RE: SEAR's response Blessed Carlo College, Moama (SSD-24262975)

Thank you for allowing Murray River Council to provide comments in relation to the Blessed Carlo College, Moama (SSD-24262975), as a precursor to the Environmental Impact Statement (EIS) process. As outlined the development is proposed to be located in the Murray River Local Government Area (LGA) and includes the construction and operation of a new catholic school for K-12 students for 500-600 students and approx. 100 staff.

Figure A1: Site Plan

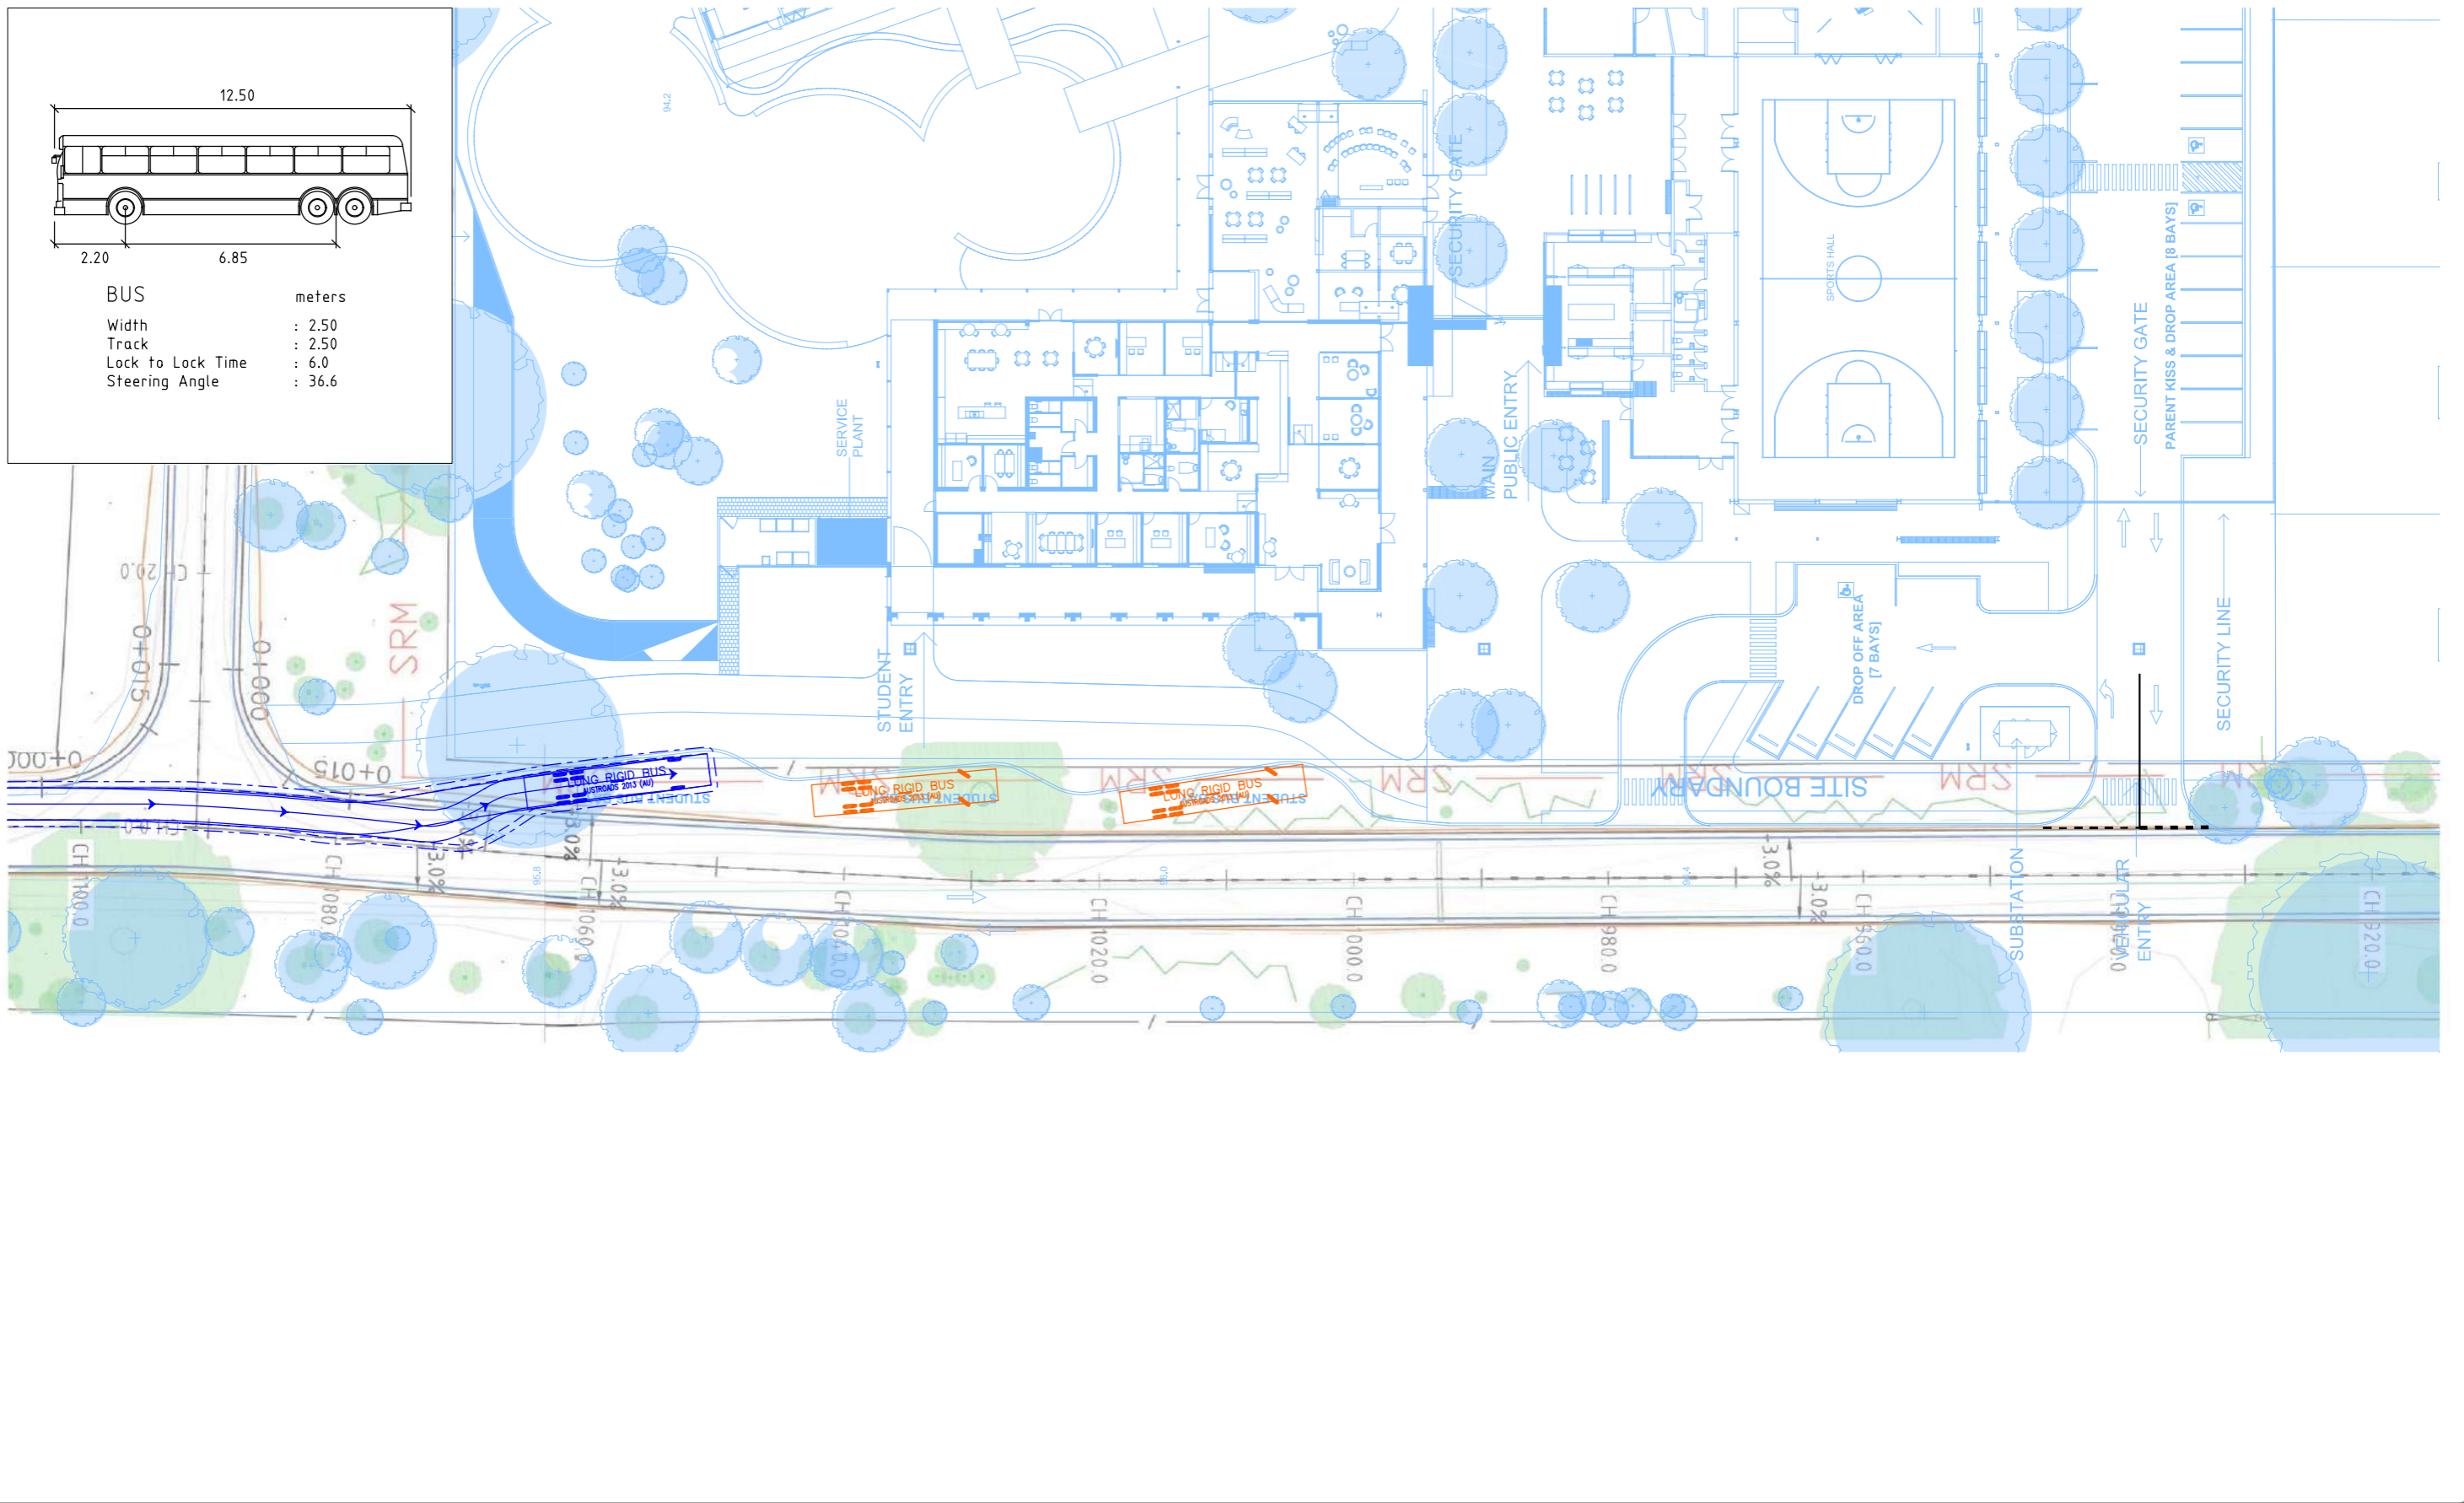
- Council requires a CHR and AUL treatment be installed on Lignum Rd intersection with access road for proposed carpark (Fig. 2.26c AGTM6) ***Note Perricoota Parklands and Arthurs Estate North and South of development on Perricoota Rd will be installing turning treatments.**
- Construct kerb and 40mm asphalt wearing surface on Lignum Rd for section adjacent to boundary West boundary.
- Fence and bollard Kiely Road reserve at Lignum Rd and North-East boundary of development to minimise risk of vehicles entering reserve area for risk to public safety and to preserve environmental area.
